Response to Planning application from Hertfordshire County Council (T and CP GDP Order 2015)

District ref: 6/2023/2180/COND
HCC ref: WH/18816/2023
HCC received: 6 November 2023
Area manager: Matthew Armstrong
Case officer: Matthew Armstrong

Land to the north east of King George V playing field, Northaw Road East Cuffley, Potters Bar EN6 4RD

Submission of details pursuant to condition 12 (engineering designs and construction of Northaw Road East access and highway works) on planning permission N6/2015/1342/PP

DRAWING TITLE  
**S278 ENGINEERING LAYOUT**

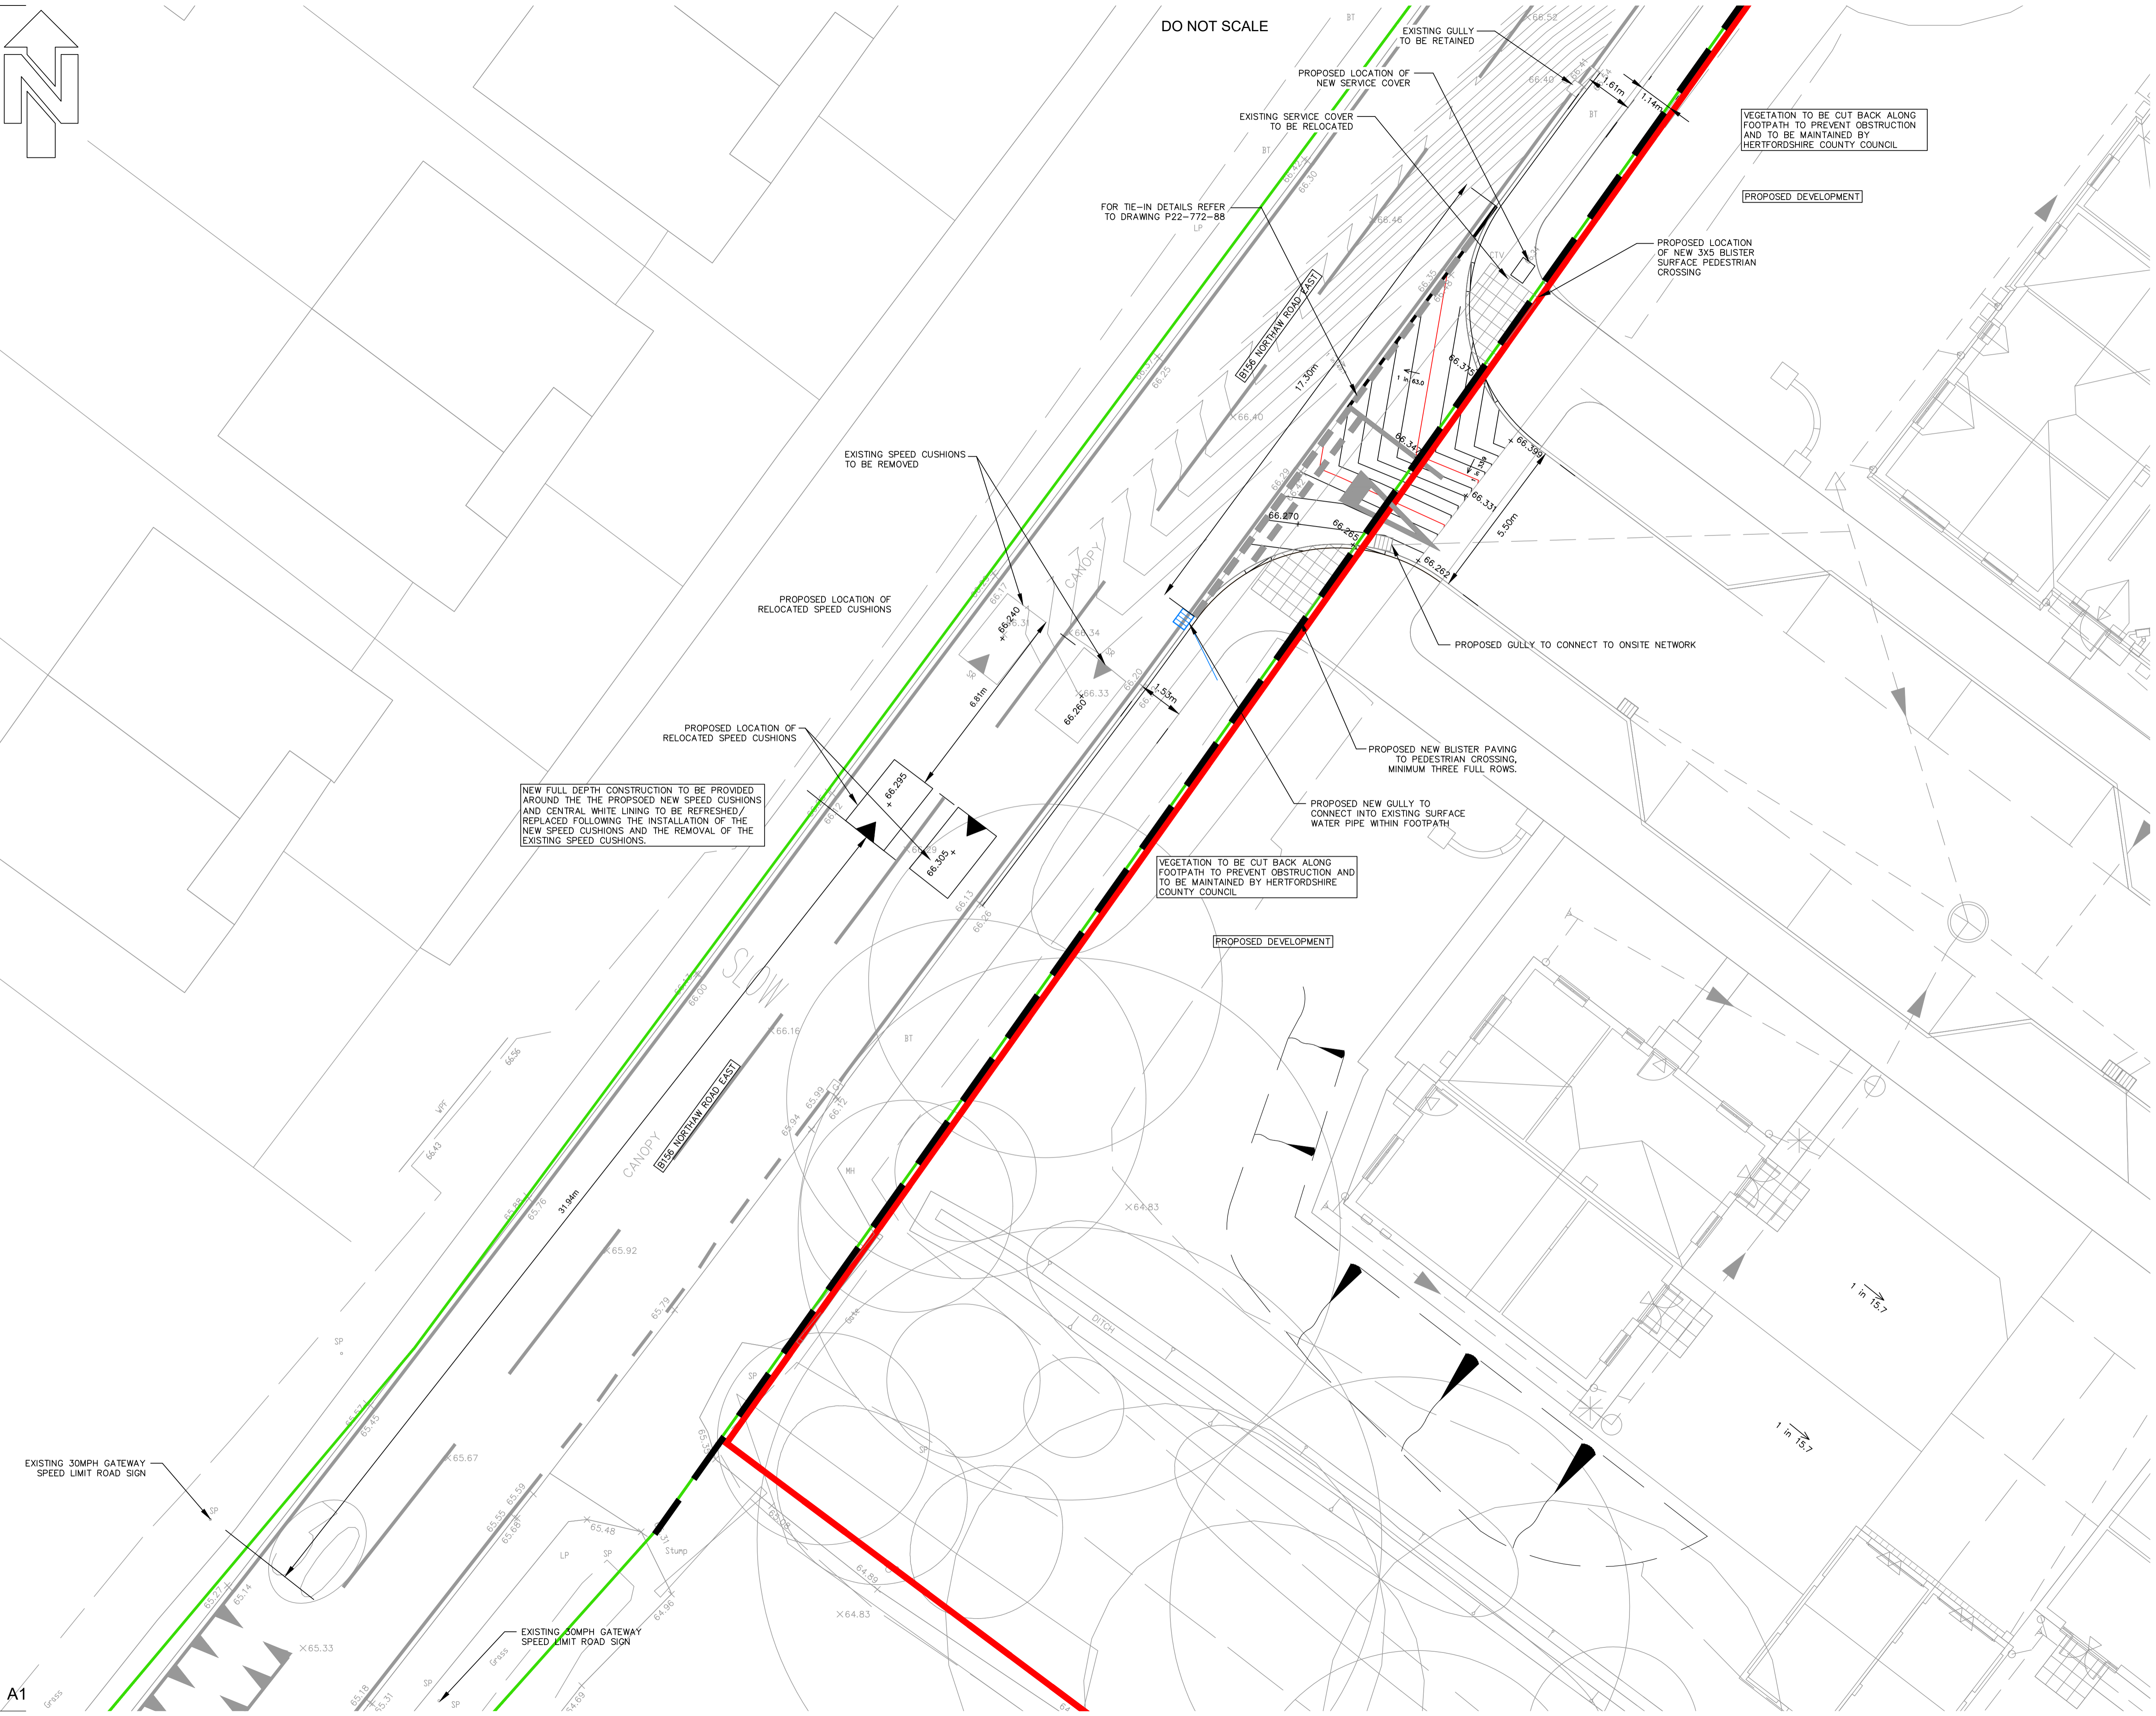
COMMENTS: The condition requires submission and approval of detailed engineering drawings (i.e. approved s278 plans). For this planning application, the applicant has submitted s278 plans which have slightly changed through the s278 process, and which themselves have not yet received Technical Approval. Once the latest s278 plans receive Technical Approval and are submitted as part of this discharge of condition, the first part of the condition can be discharged. As the works are not in place on the ground, it is premature to discharge the second part of the condition.
